Your ref:  
Our ref: 23/02030/F  
Please ask for: Valera Lvov  
Direct dial: 01553 616865  
E-mail: borough.planning@west-norfolk.gov.uk

17 November 2023

Details: **Change of use of house and garage to dog breeding business at Aviary House  
Mill Drove Southery DOWNHAM MARKET Norfolk**

Location Plan

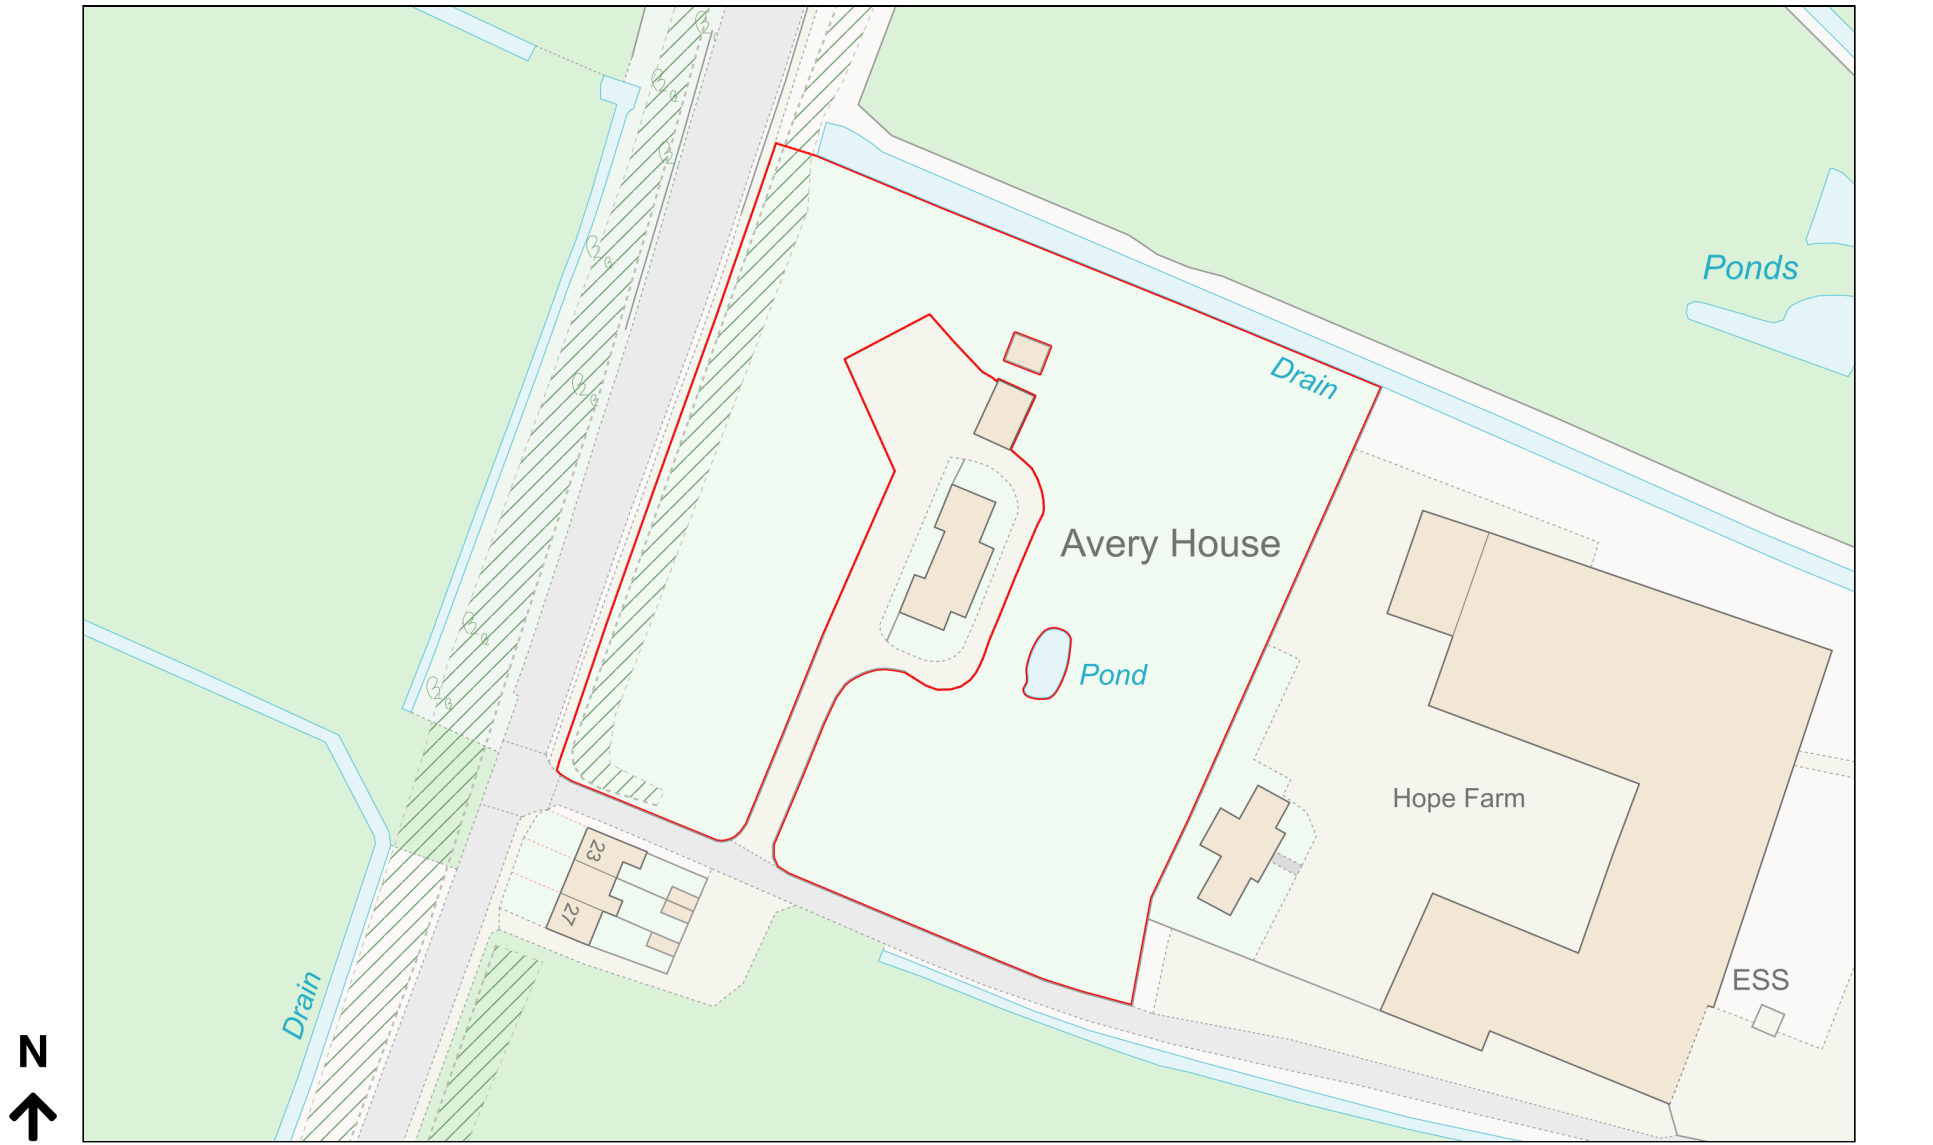
1. Please check the location plan, currently it appears to exclude the access and the dwelling house as they are not within the red line. The site should be edged in red and any other adjoining land owned or controlled by the applicant edged in blue. Location plans should be to a scale of either 1:1250 or 1:2500.
2. A Flood Risk Assessment is required to be submitted with this application, as the site lies within an area at risk of flooding.
3. At the time of writing, the application fee has not been received. The fee for this type of application is £462.
